10 December 2021

Our Ref: 34199/06

Your Ref: Y/127/21/RES

Land off Bilsham Road, Yapton.

BASIN SECTIONS

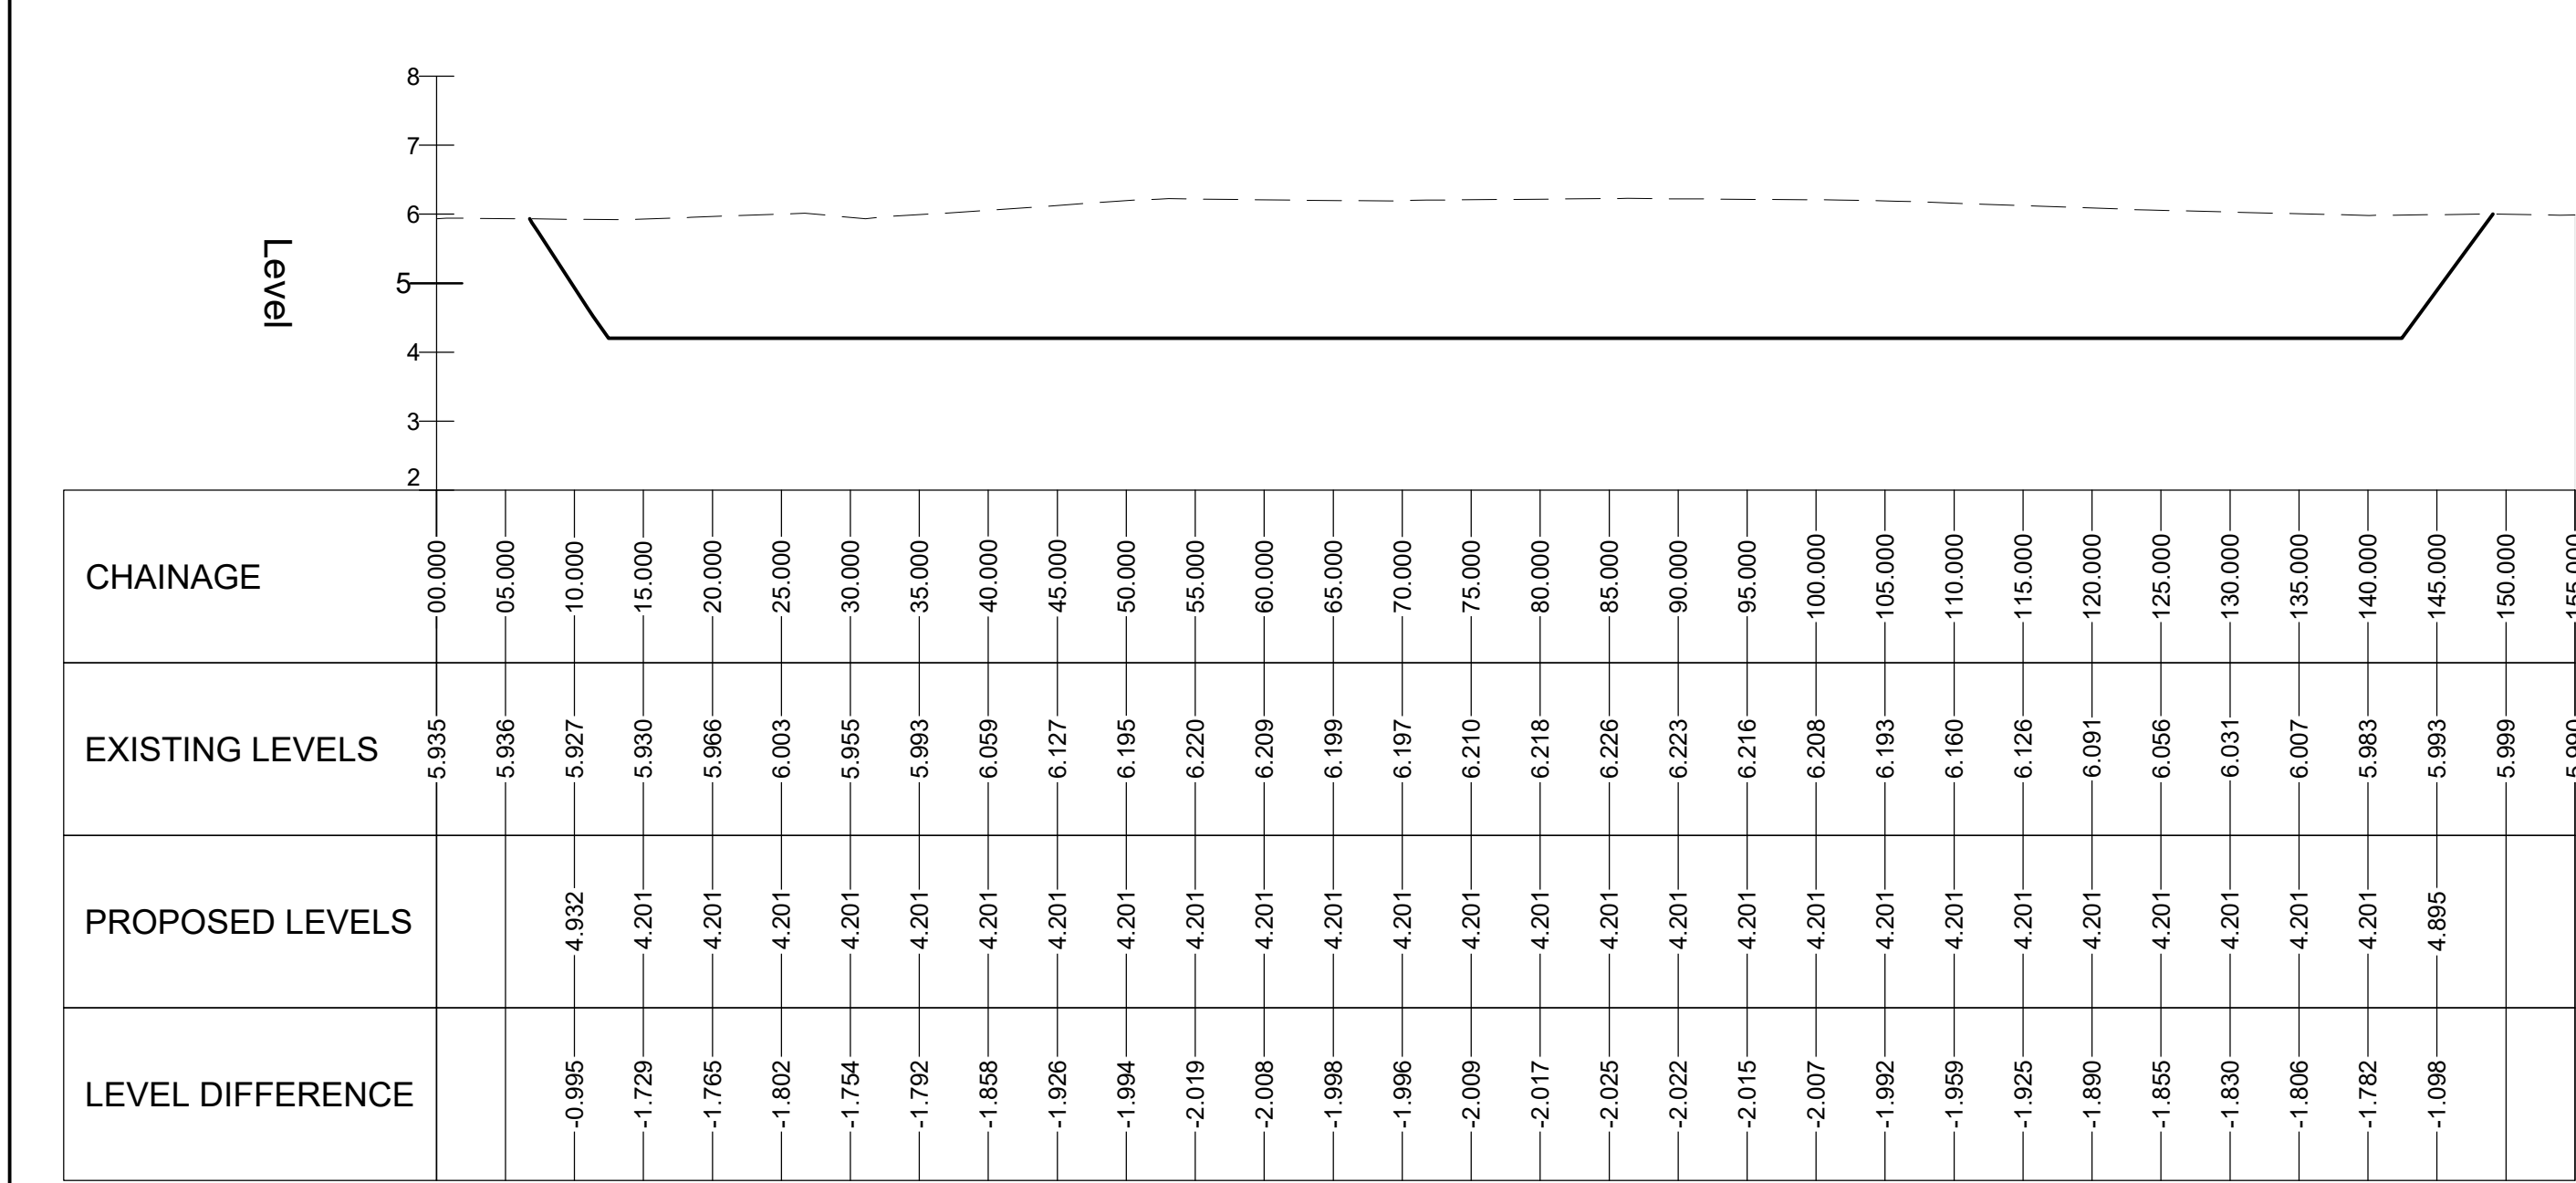
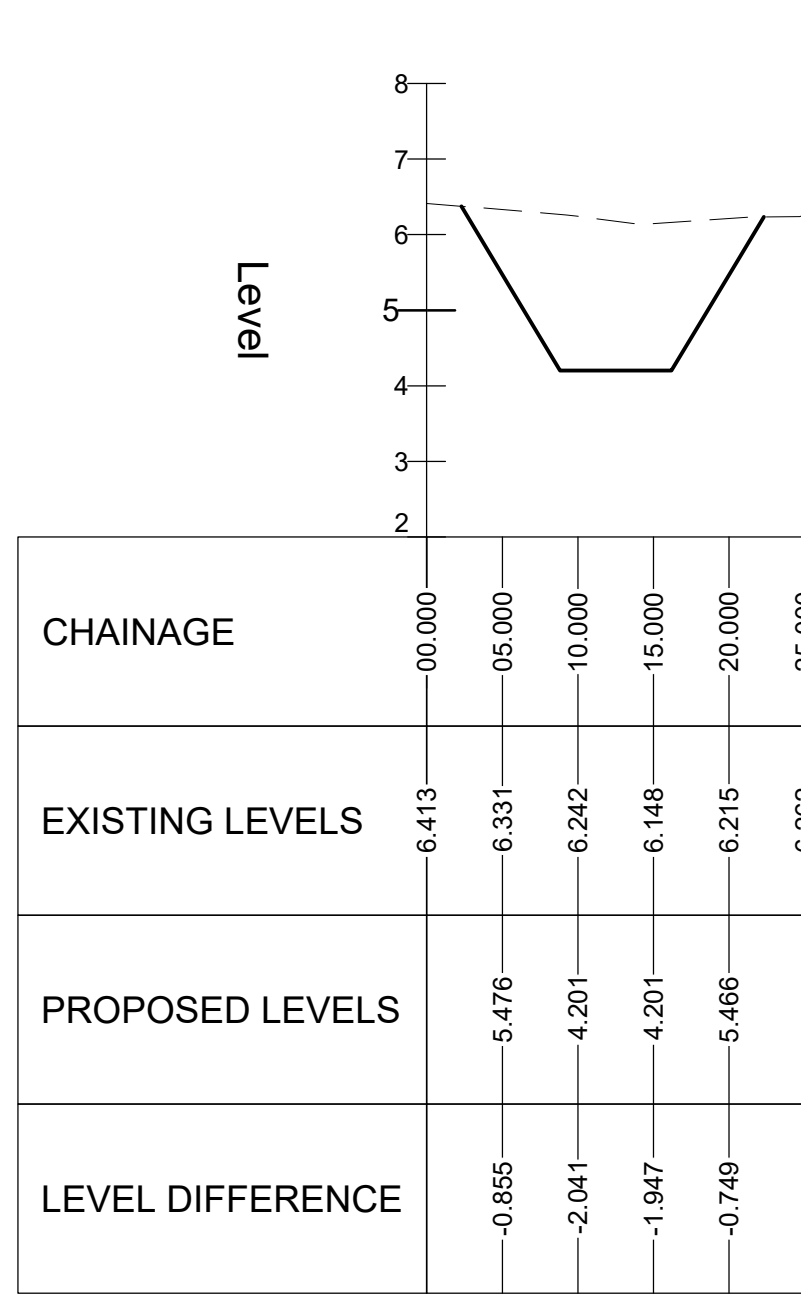
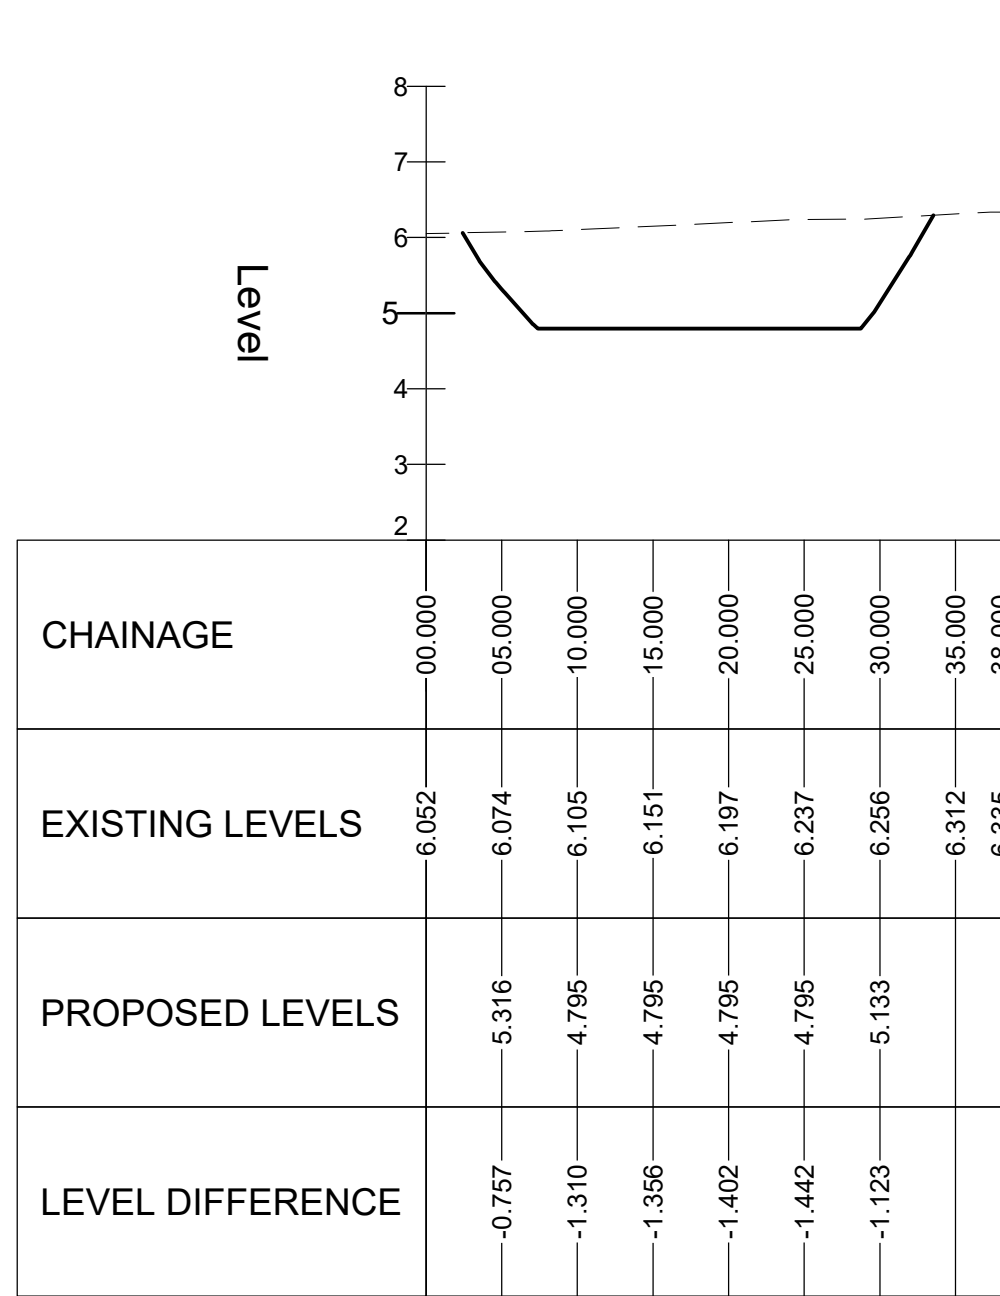
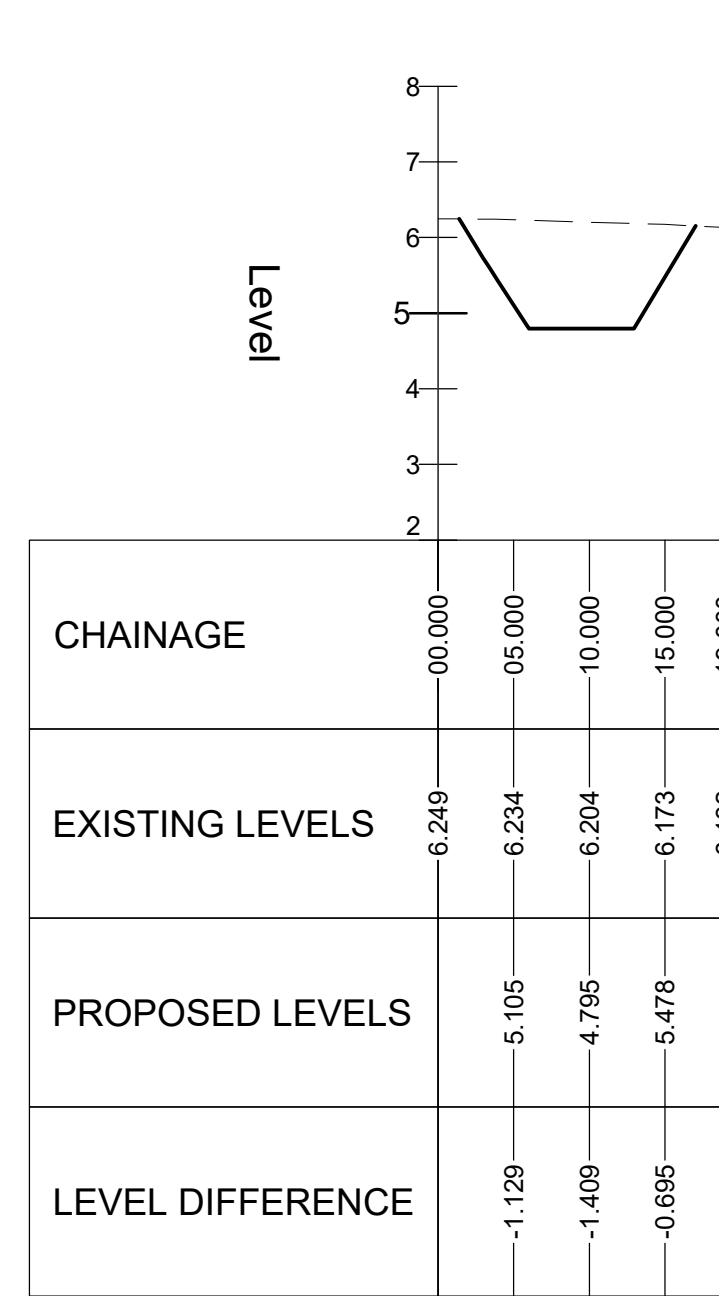
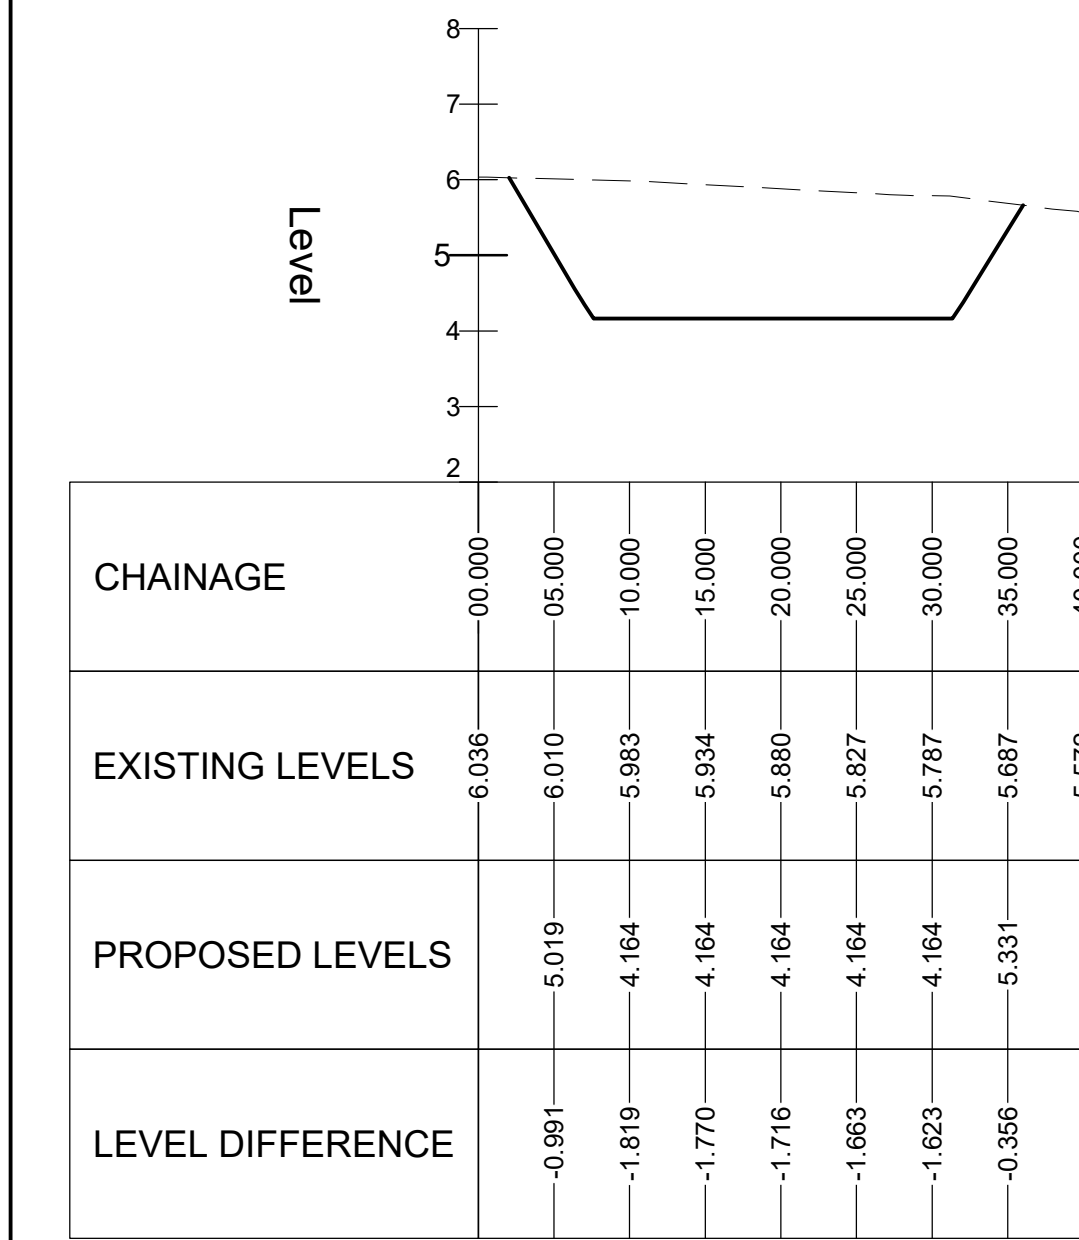
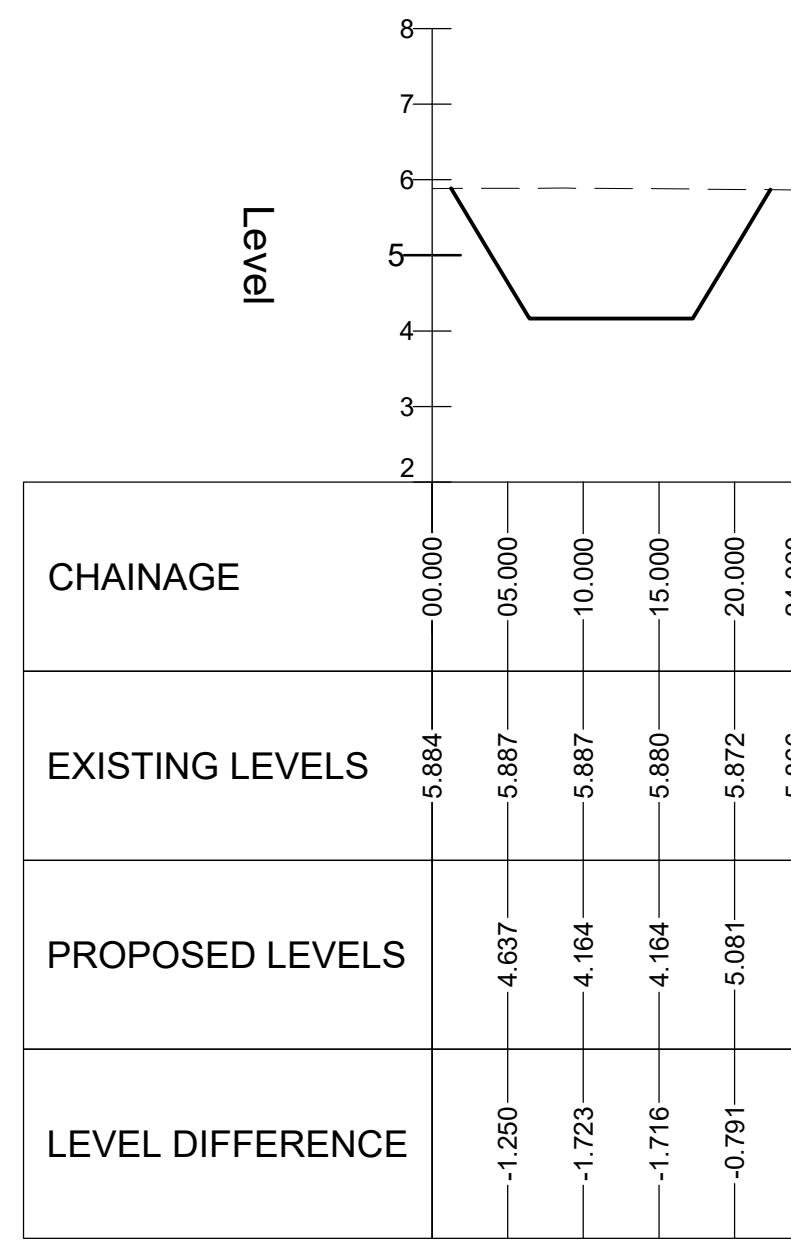
Two perpendicular cross sections per basin

This information has been prepared and submitted with this cover letter under drawing ref: 19-326-017 Basin Sections.
